Subject: RE: Attached letter from Kirklees Council regarding application number 2025/90689 at location Penistone Road/, Rowley Lane, Fenay Bridge, Huddersfield, HD8 0JS

I would like to advise that conditions 25 (retaining walls) and 26 (attenuation system) can not be discharge pending the approval of the necessary details, as stated below;

Detail
SITE SECTIONS - G-G TO H-H

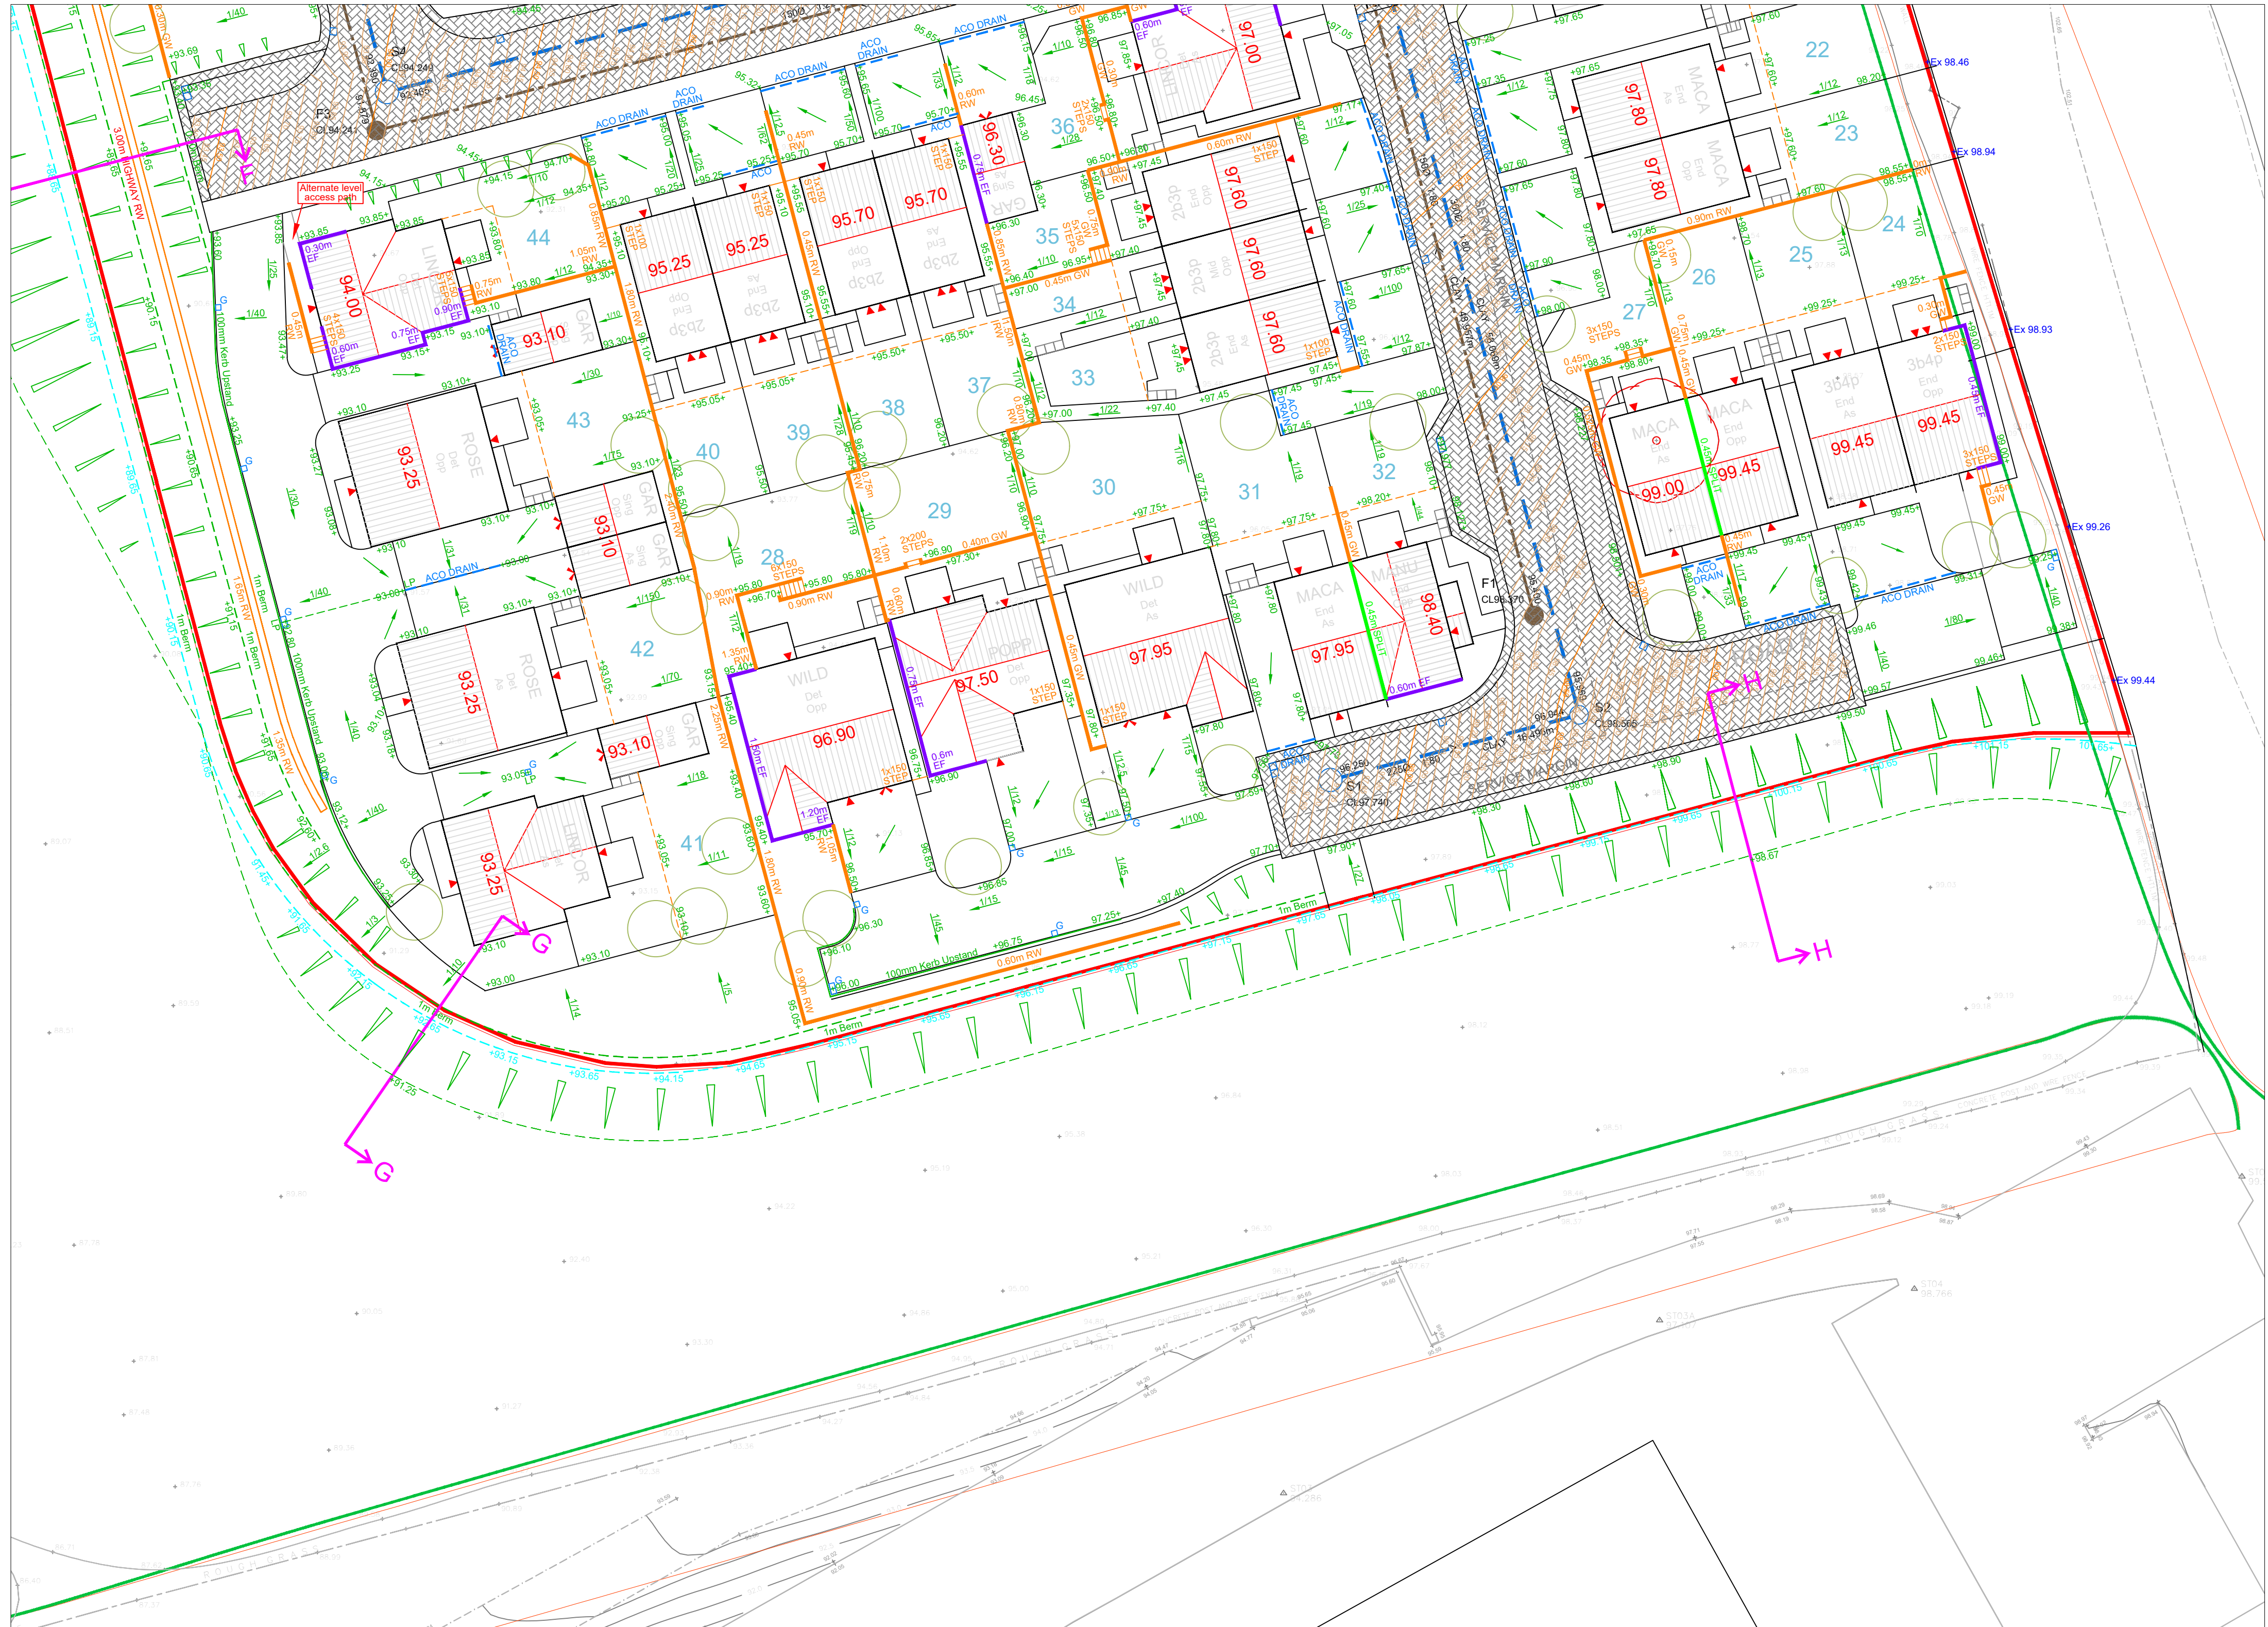
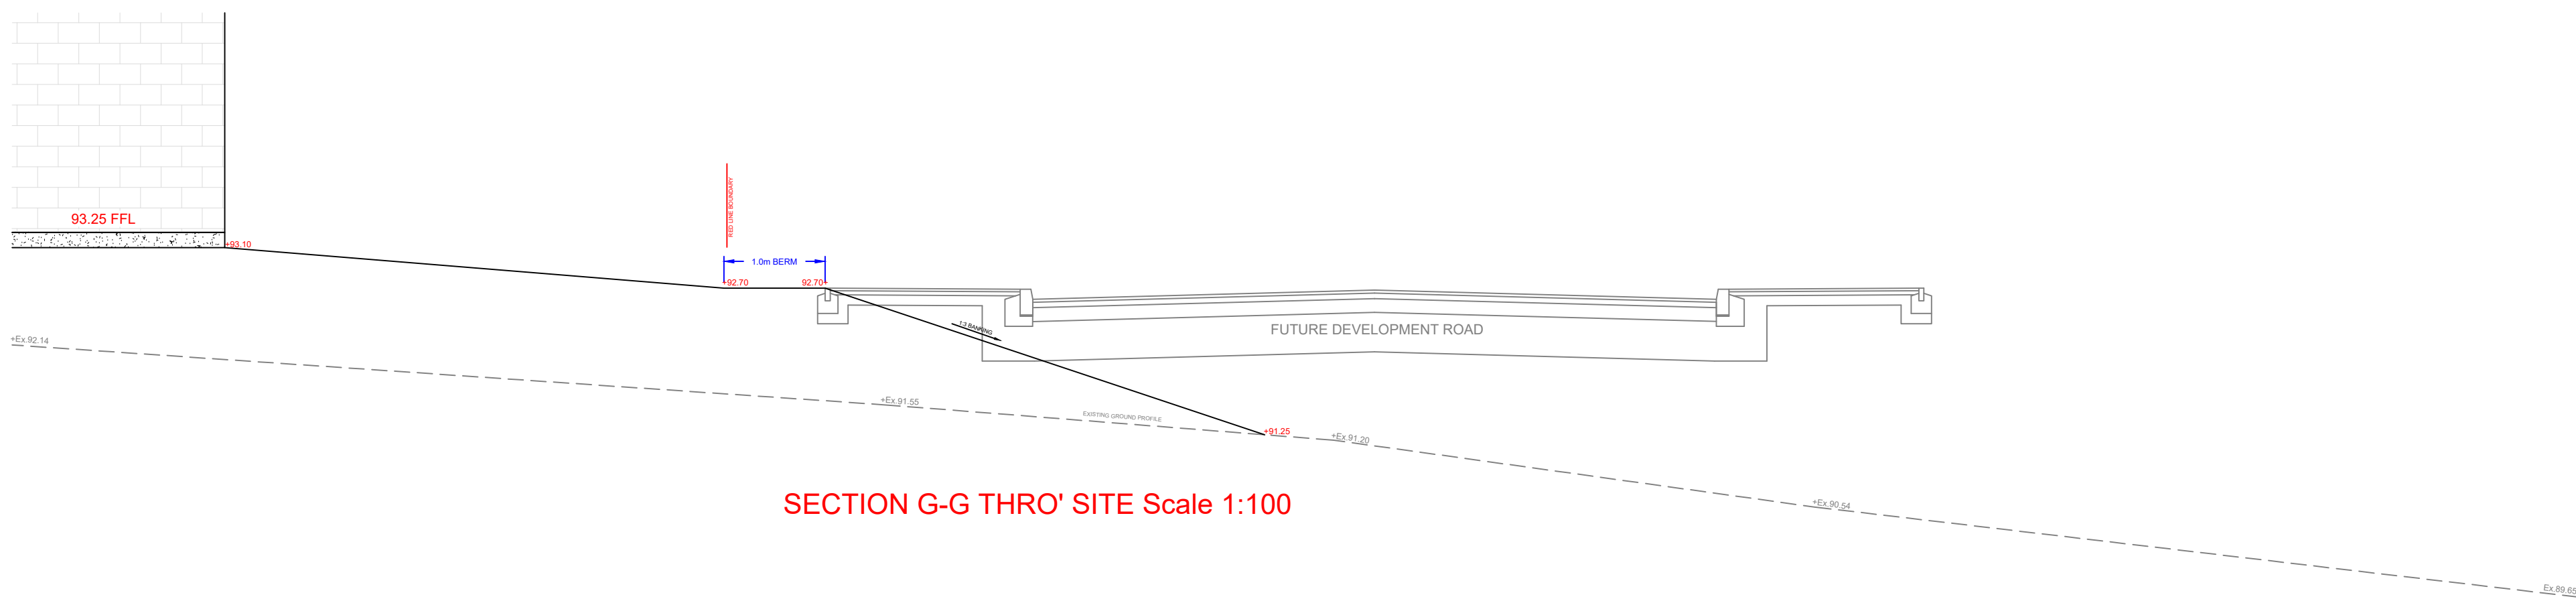
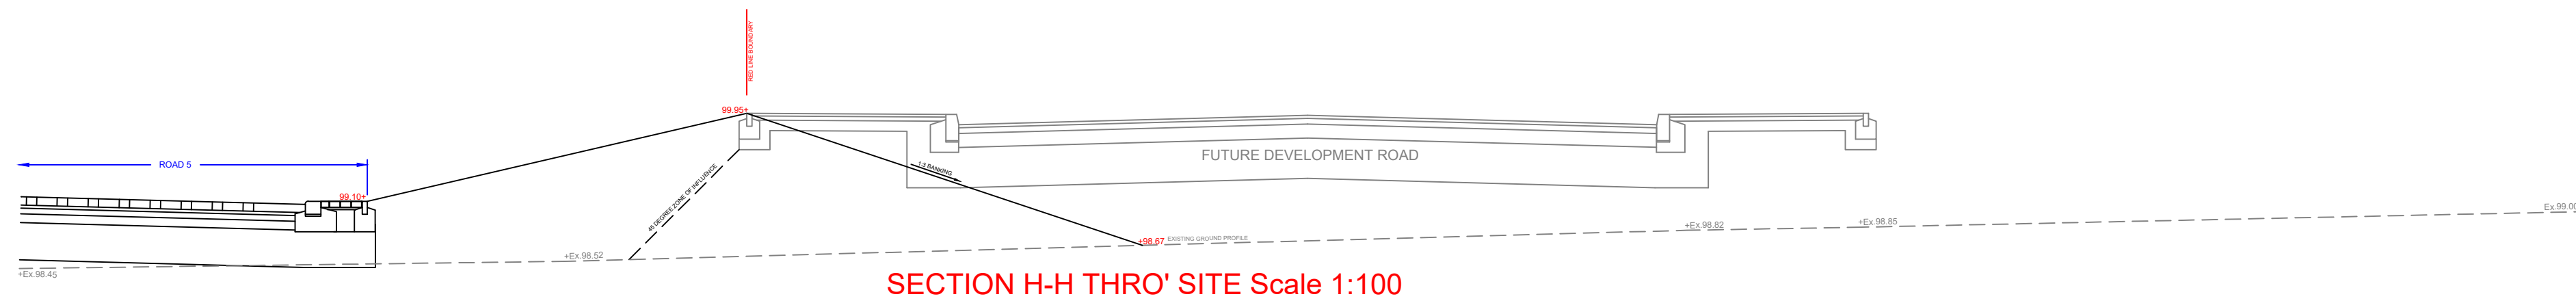
- 1) Submission of suitable of external works drawing for the whole site with appropriate keys for the relevant proposed retaining walls/embankments adjacent to the highway, adoptable highways and the confirmation of location and status of the road labelled “Future Development Road” as well as specifying the lateral dimensions between the proposed structures and adjoining Road on the submitted sectional details to ascertain whether these retaining structures will be liable to a formal technical approval via submission of AIPs.
